# ENG-SF20015-R3-CD-redlines.pdf Markup Summary

STRM_19 PROFILE STA 0+00.00 TO 13+29.82 PRIVATE (SRMD)

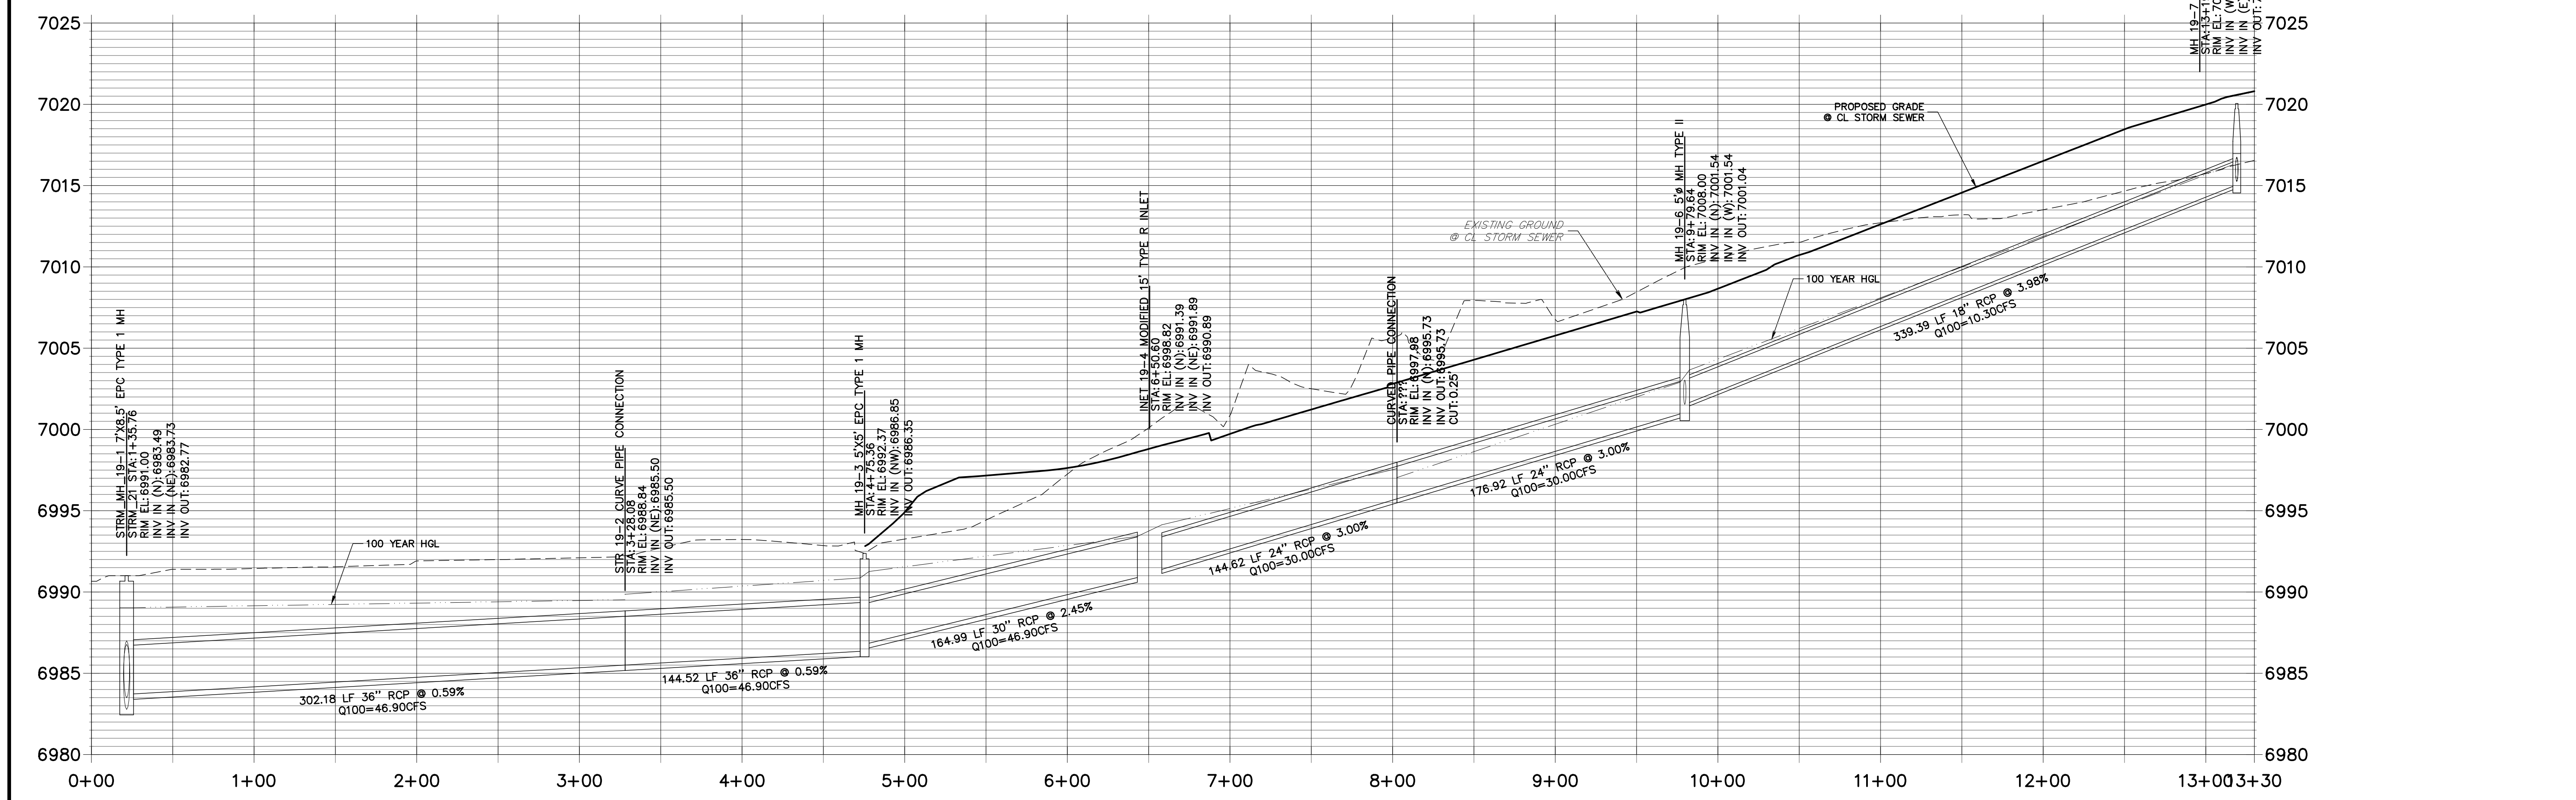
Pipes with watertight joints require 100-year design life.

**TEMPORARY DITCH PROFILE
STA 0+00.00 TO 12+00.00**

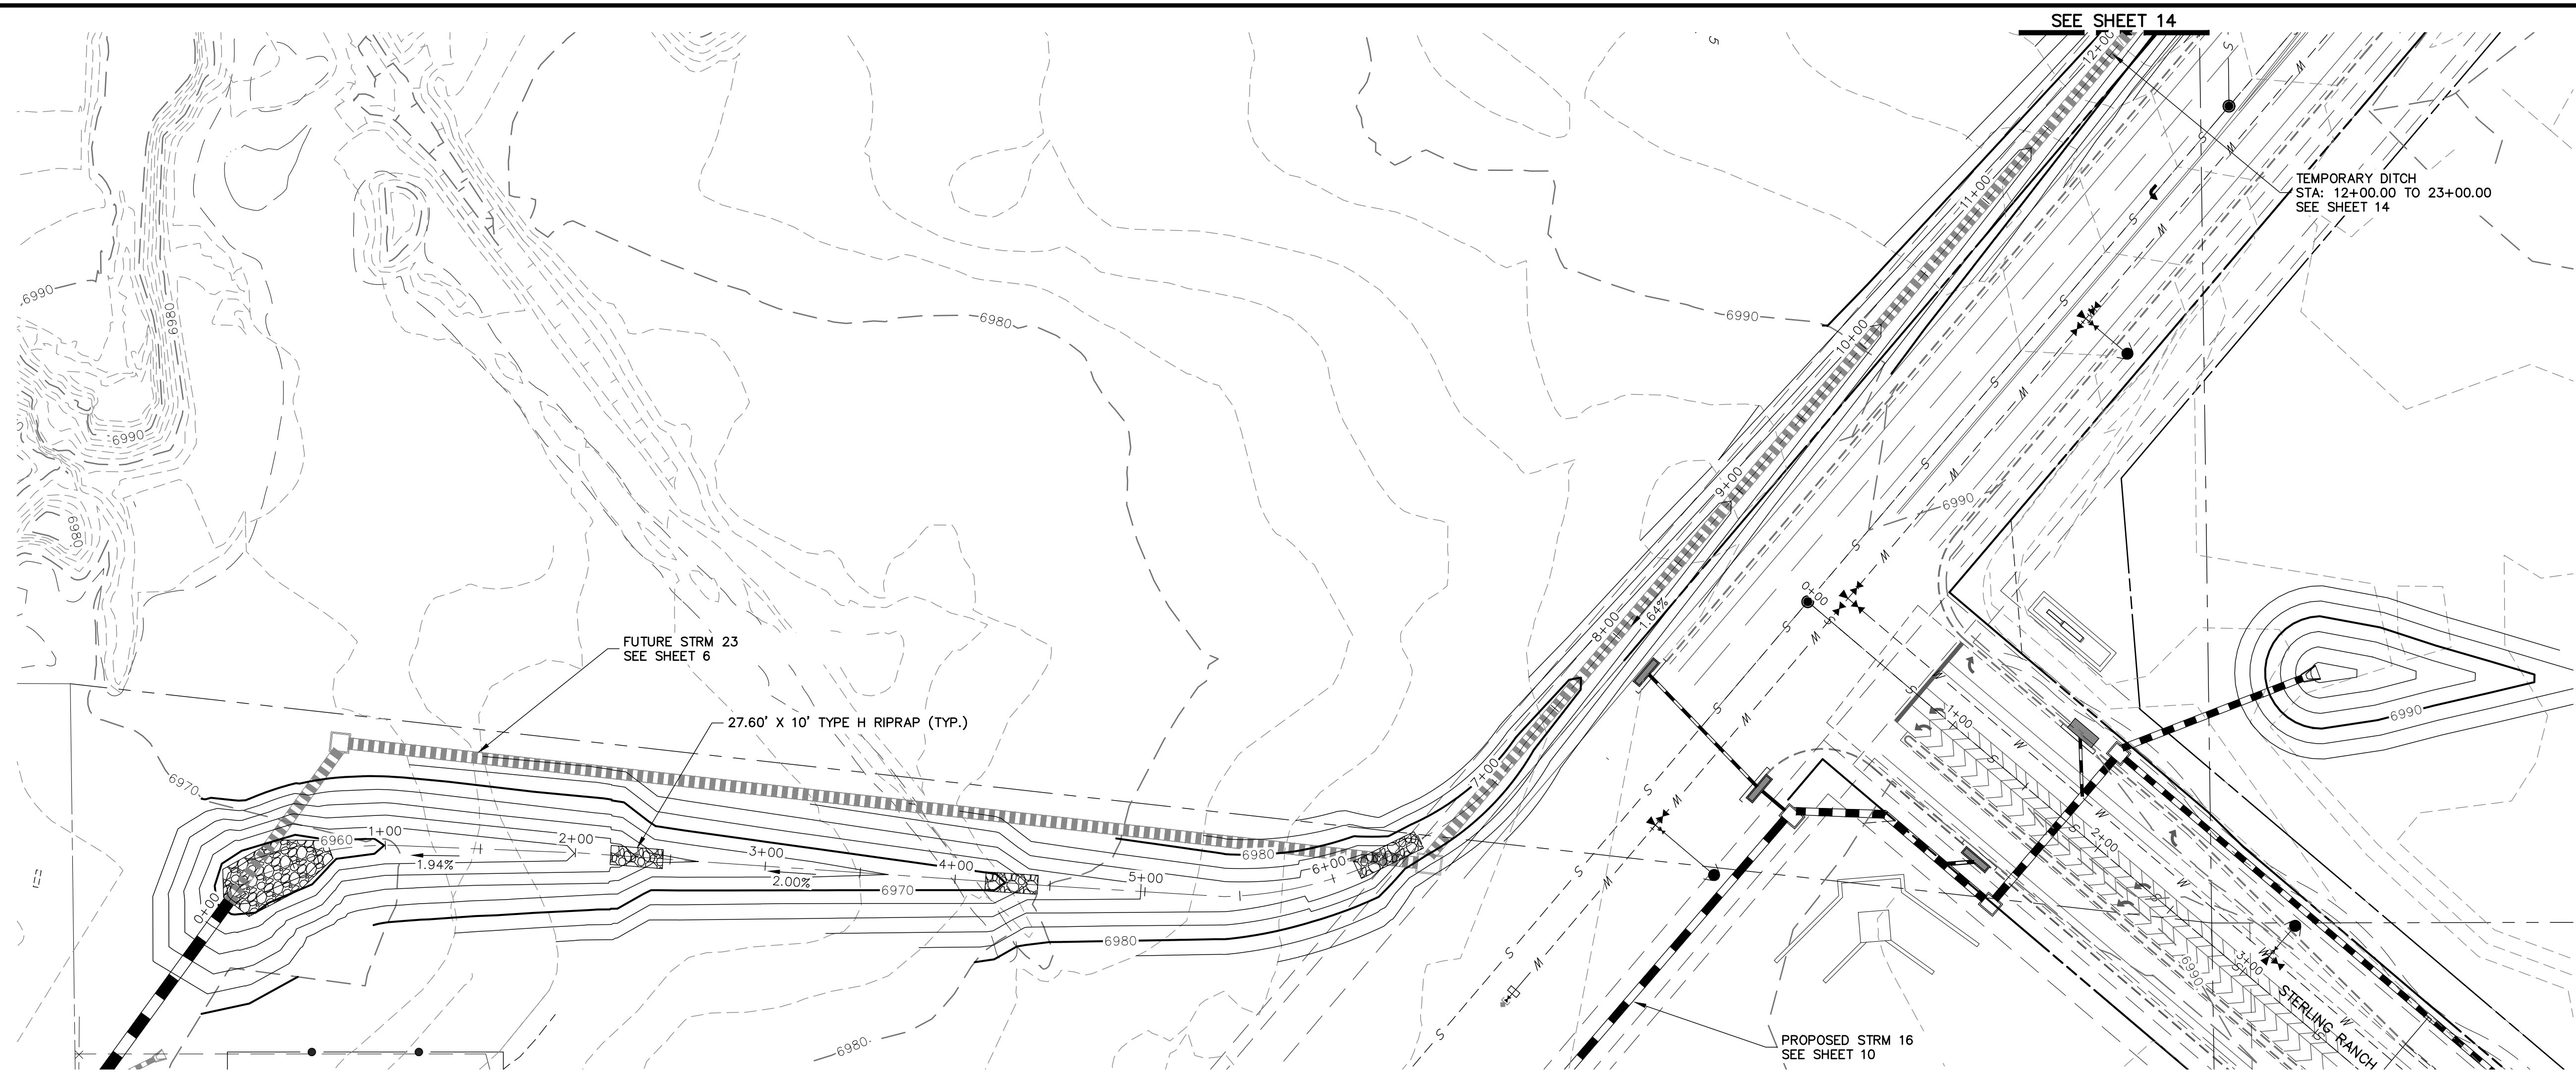
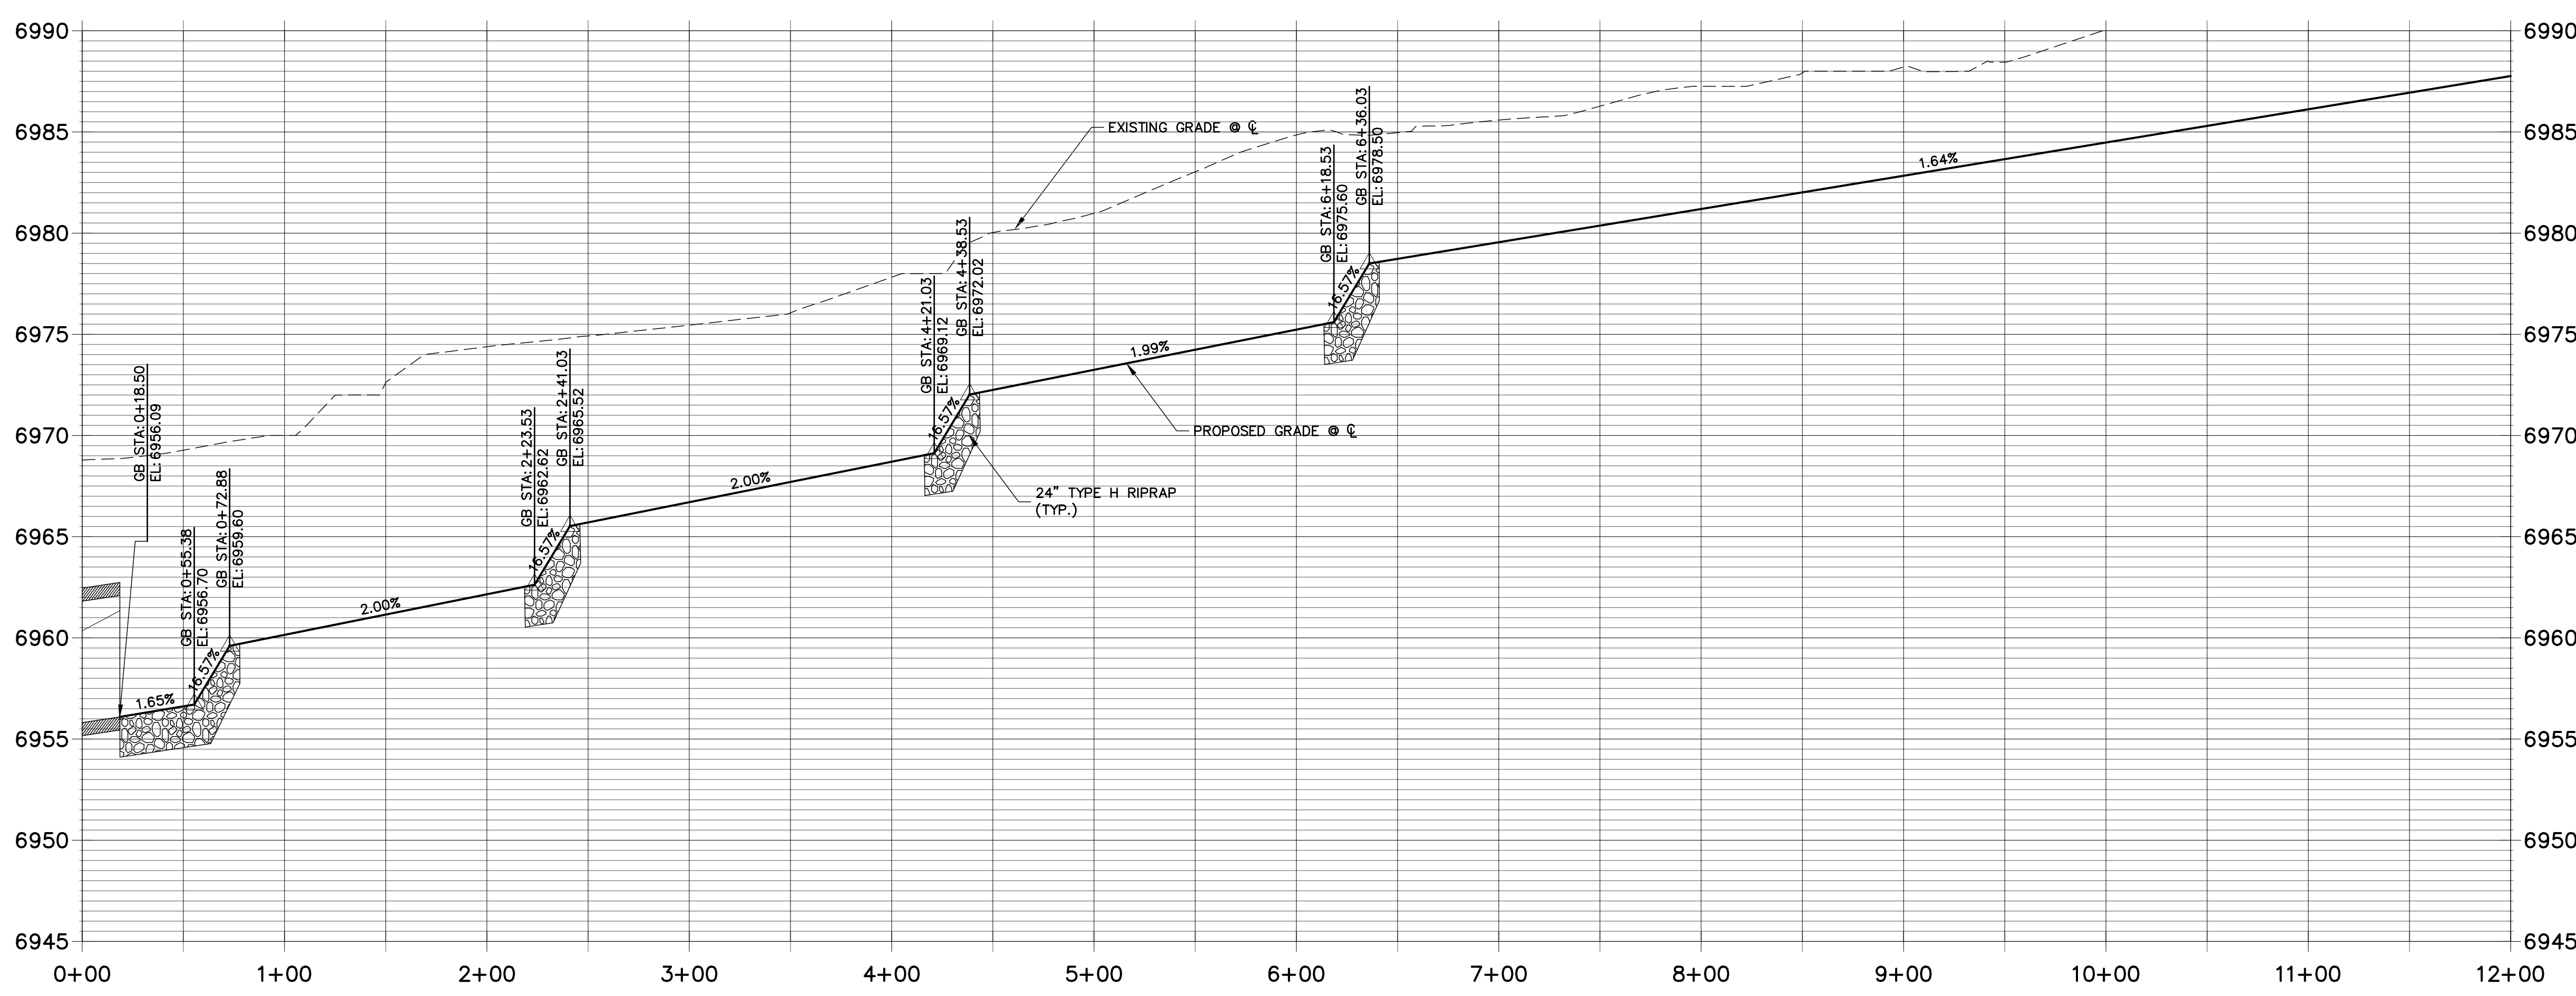
Label ditch lining.

Label ditch lining.
